FULL

Reference: H18-0886-23 **Date of Decision:** 21st November 2023
Applicant: Mr J Robinson & Miss R Hammond
110 New Road
Sutton Bridge
Spalding
Lincolnshire
PE12 9RQ
Location: 110 New Road Sutton Bridge Spalding
Description: Demolition of existing bungalow and erection of detached dwelling - re-submission of H18-0479-23

South Holland District Council hereby give notice that this application has been REFUSED for the above proposal for the following reason(s):

Proposed Side (N) Elevation
Scale 1:100

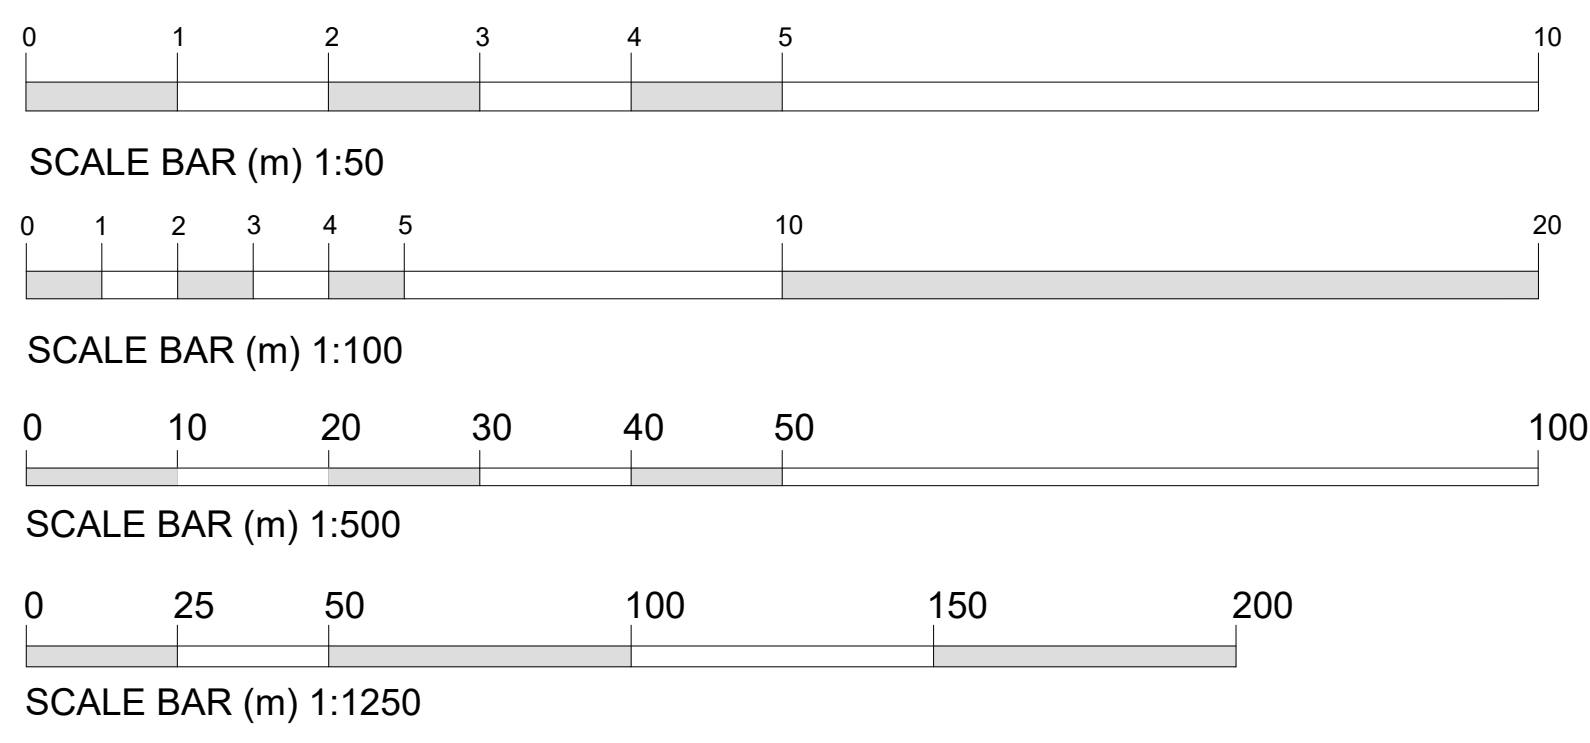
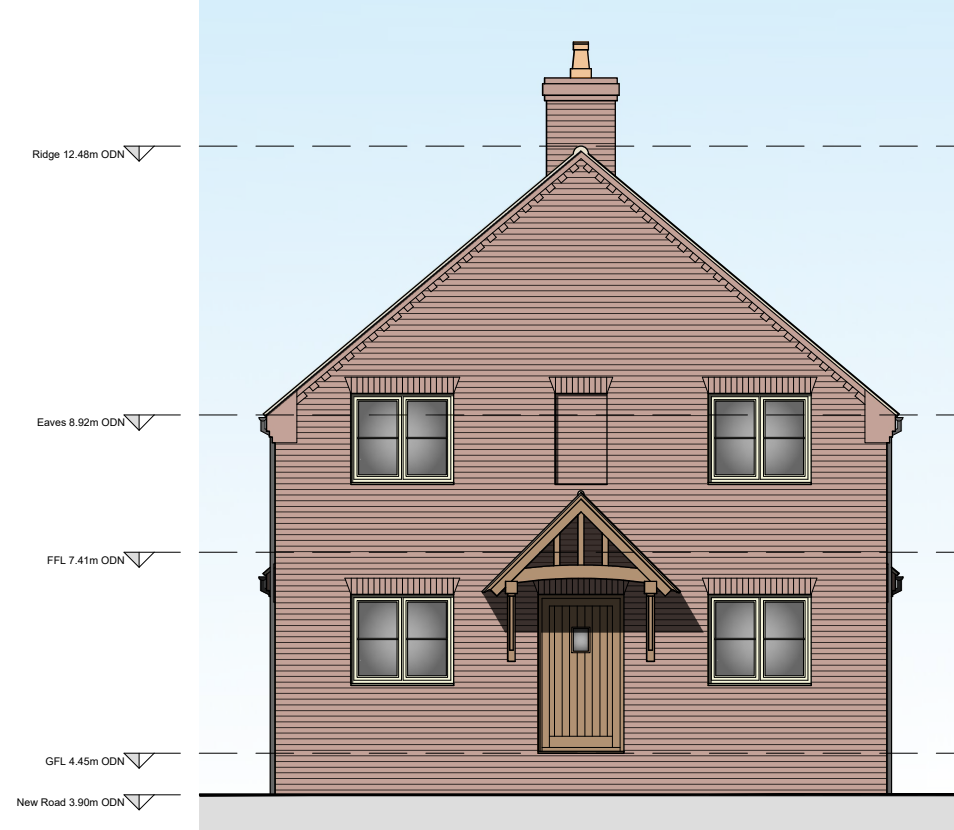
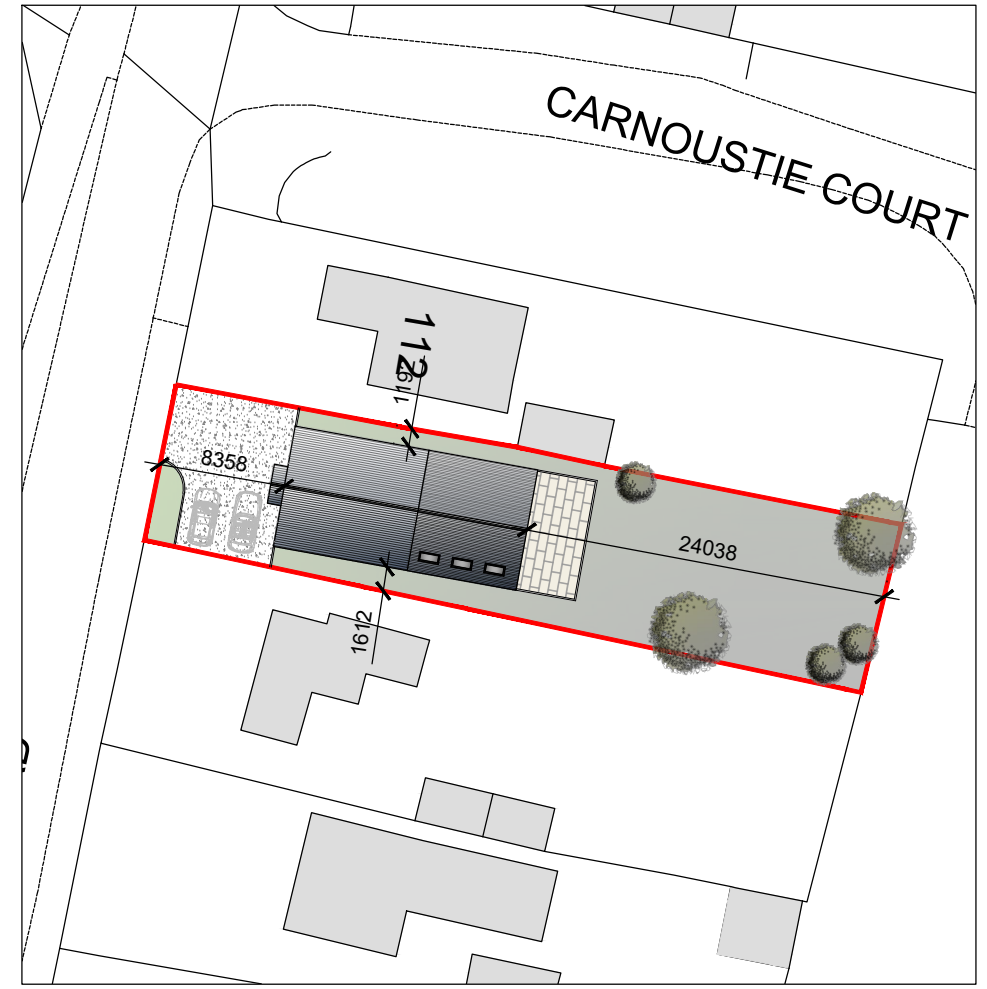
- 1 The proposed replacement dwelling would be intrusive and overbearing upon the neighbouring property's occupants to the north. The proposed development would result in an increase in built form immediately neighbouring No.112, which would be immediately north of the proposed dwelling, resulting in an unacceptable loss of outlook and loss of light to principal windows. No.112 has a first floor window facing the proposed dwelling, and although there seems to be another window serving this first floor room to the west elevation, the siting of the proposed dwelling within the plot means that the proposed dwelling would be forward of this elevation and would clearly be visible from the front windows of No.112, further increasing the impact to the neighbouring dwelling.
